Application No: AL/62/21/PL
Site Address: Paddocks Days Lane Aldingbourne BN18 0TA
Description of works: Part change of use from C3 residential dwellinghouse to Class E ancillary office space (ancillary to school) and change of use of former garage building to Use Class F1, associated with existing school.

Thank you for your internet representation made on 14th July 2021 which has been recorded as no objection with the comments as follows:

Drawing Name
**House Elevations -
Proposed**

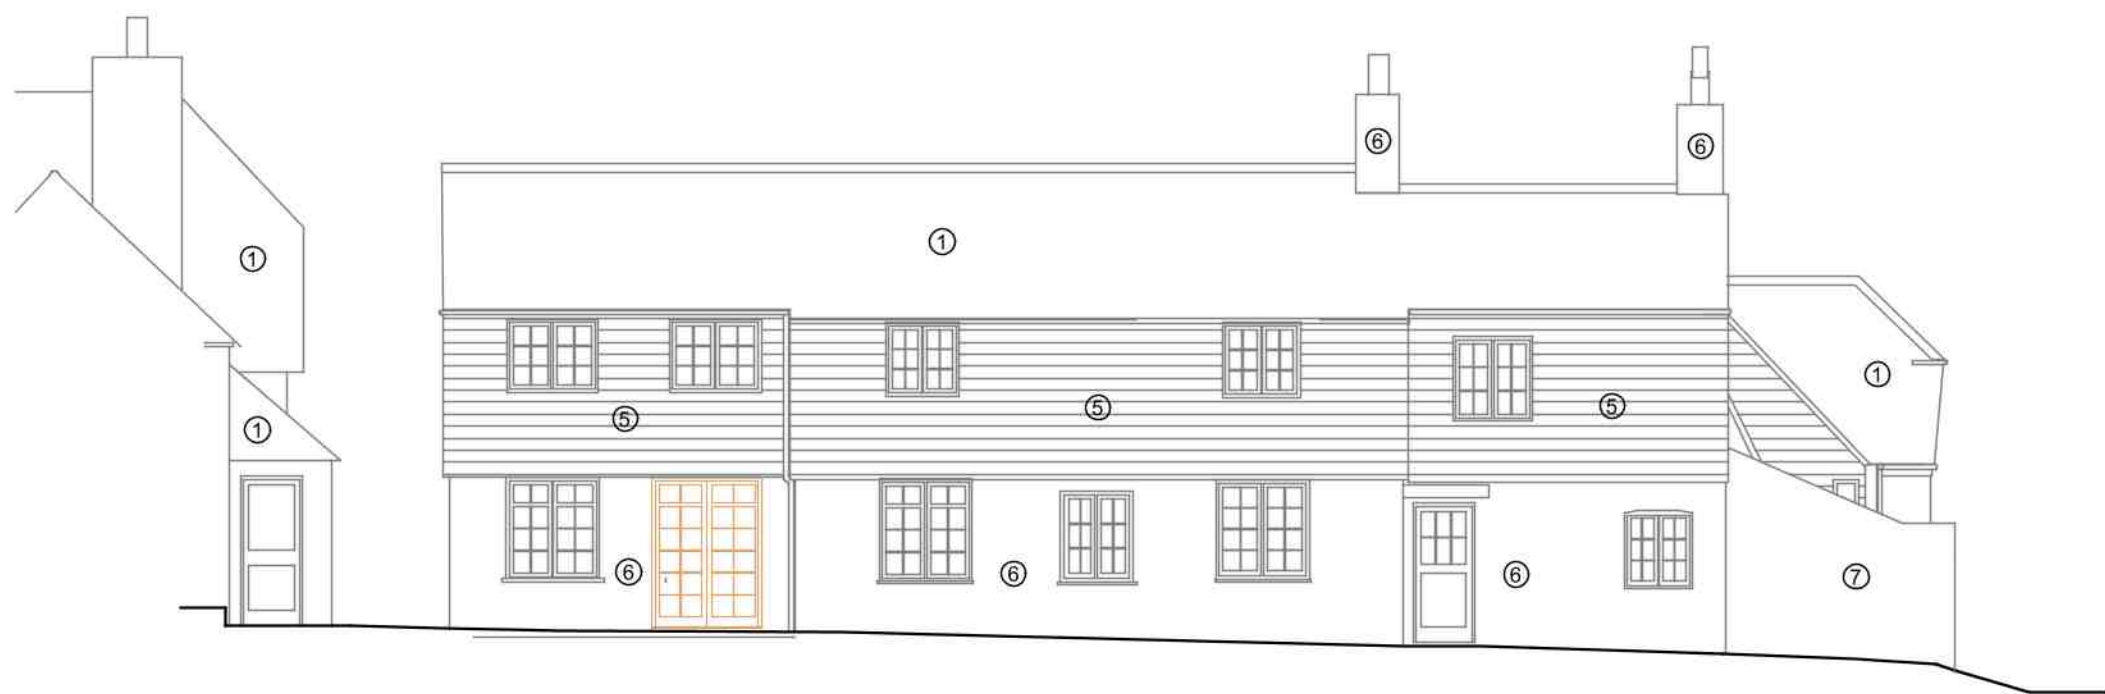
The PC supports this application but would like to note that the ANDP Policy EH10 (Dark Skies) as this application includes the addition of new windows/doors and mitigation may be required
